**Subject:** Rezoning Petition Review

**Rezoning Petition #:** 22-123

**Proposed Zoning:** R-8 (CD)

**Location of Property:** Approximately 39.02 acres located along the southwest side of Gibbon Rd, east of Statesville Rd and south of Old Statesville Rd.

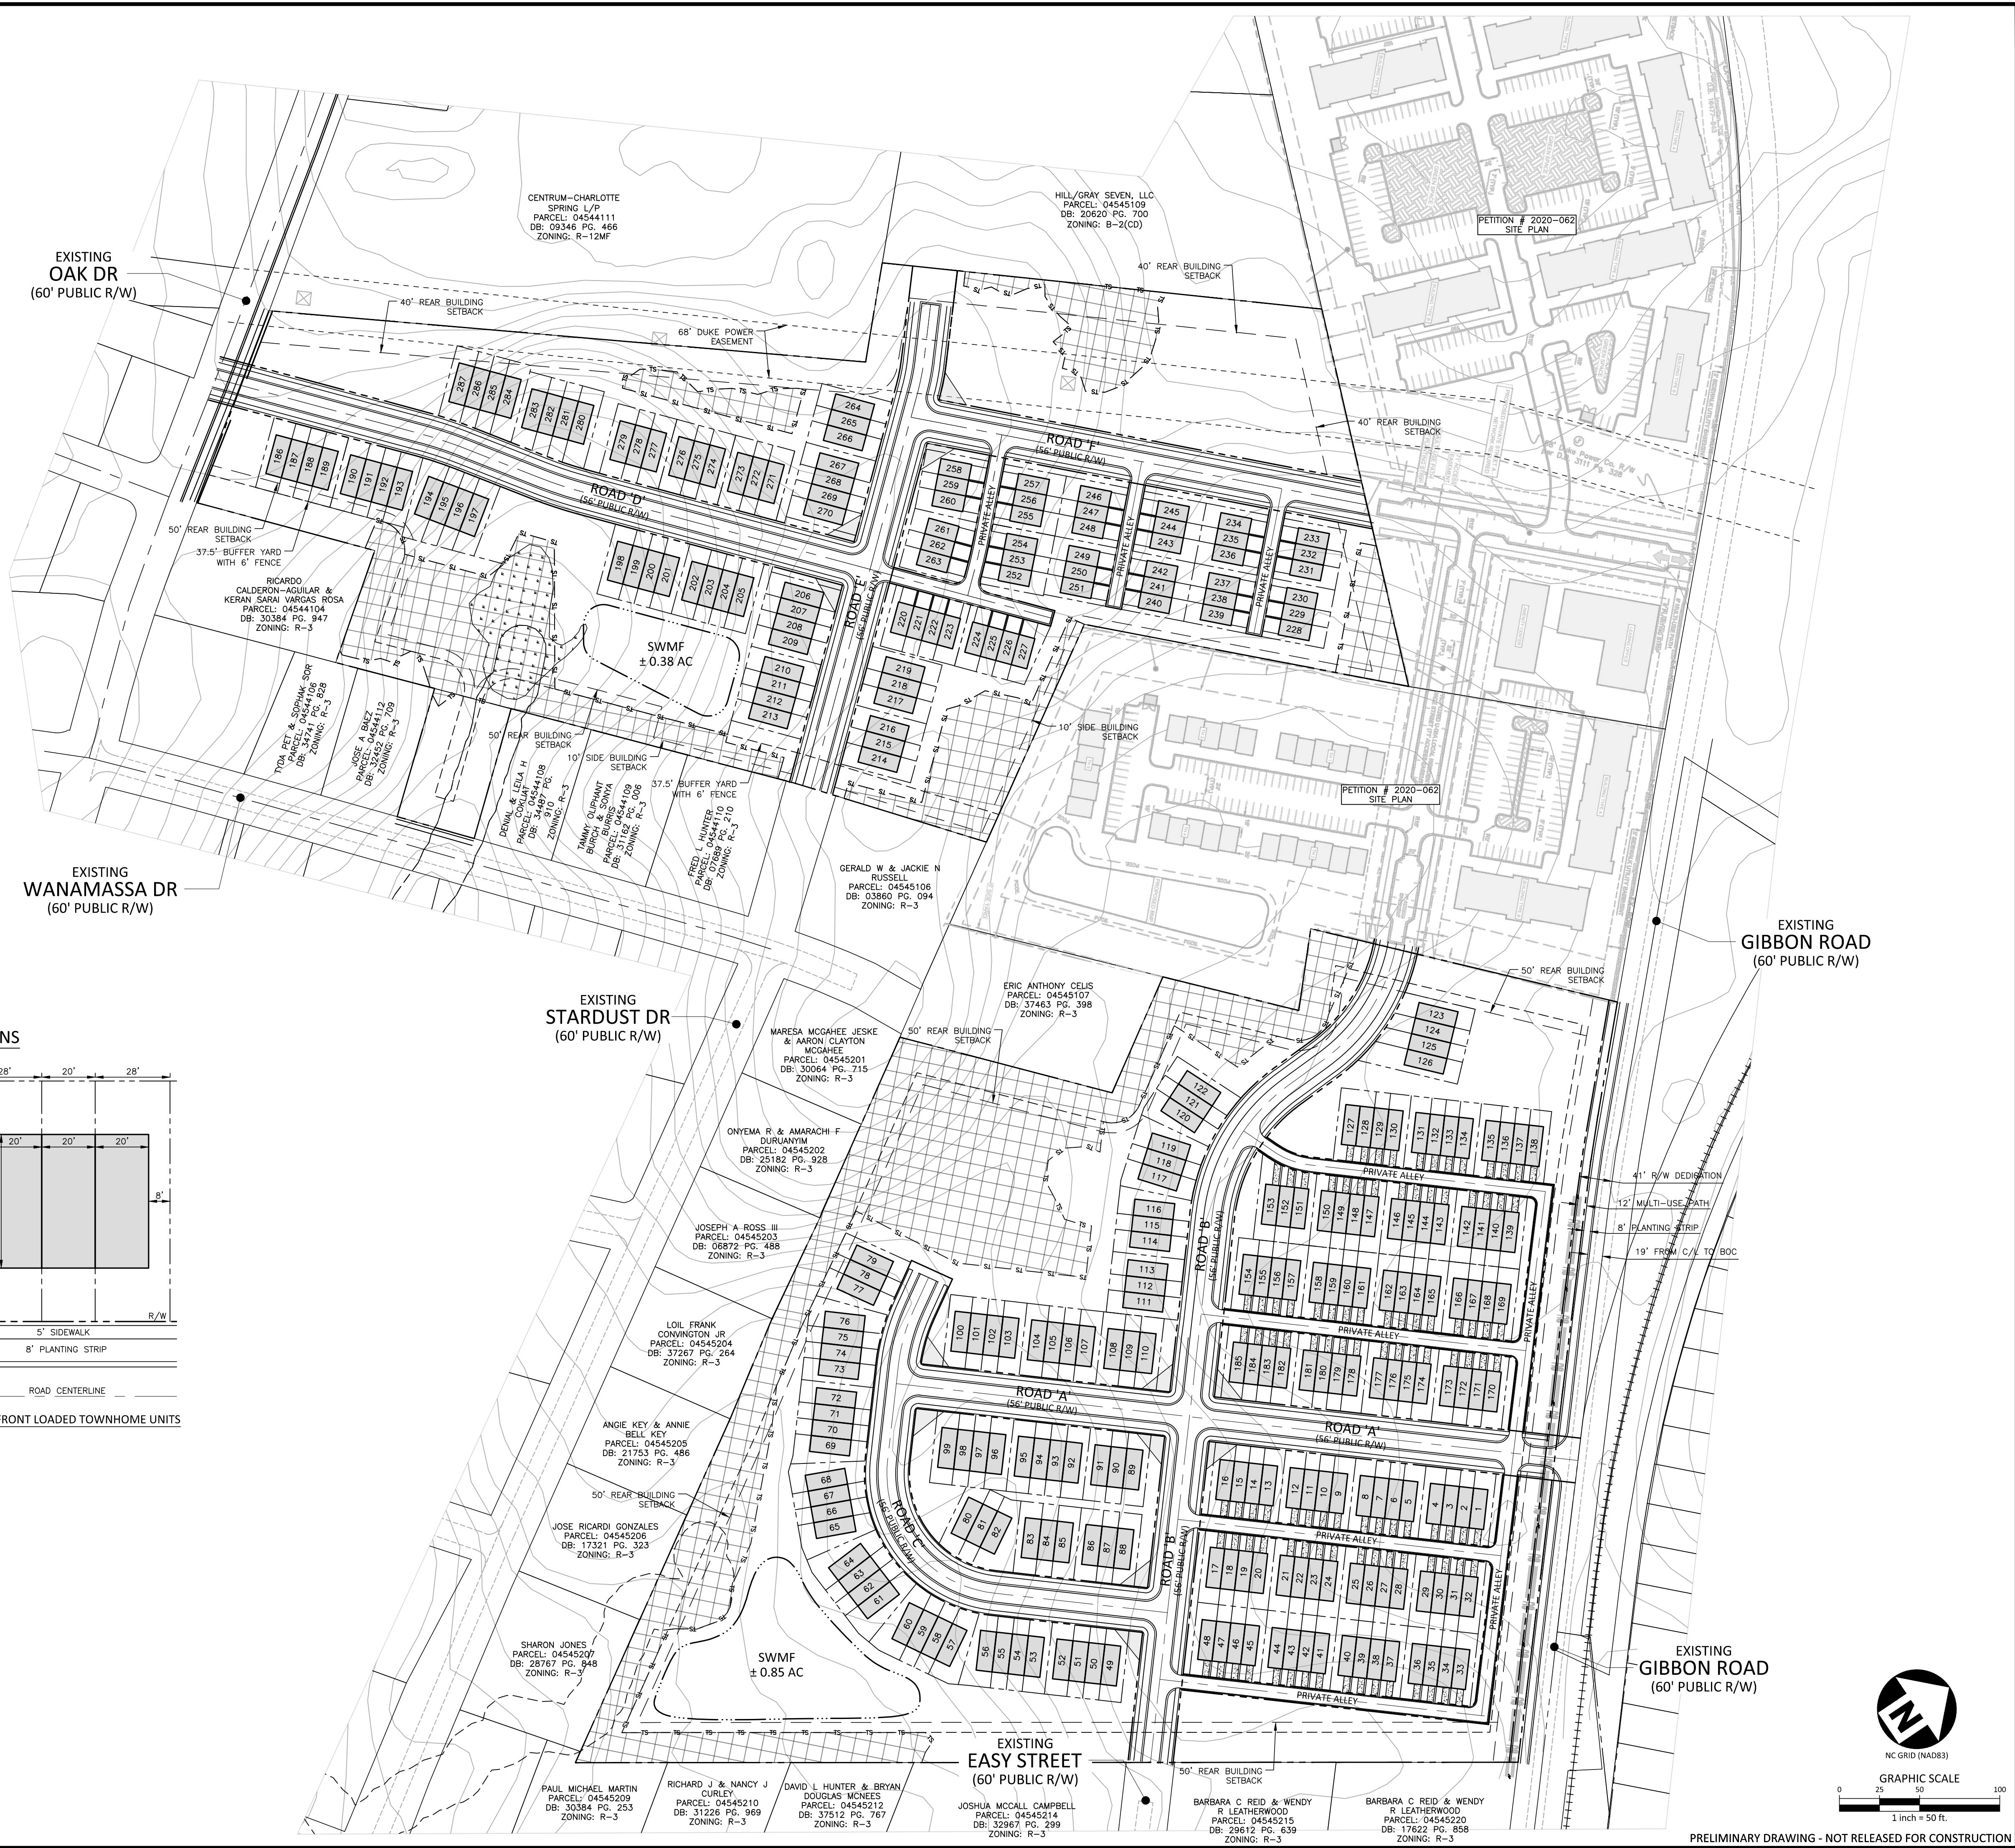
Downstream properties have Storm Water requests for service in areas of known flooding. Please include the following note under Environmental Features. *For adjoining parcels receiving storm water discharge the petitioner shall analyze the adequacy of the existing storm water conveyance on the adjoining parcels to Sampson Street. If the existing storm water conveyance on the adjoining parcels is found to be inadequate, the Petitioner shall make a good faith effort with the property owner(s) to improve the storm water conveyance or mitigate the storm water discharge onto the adjoining parcels.*
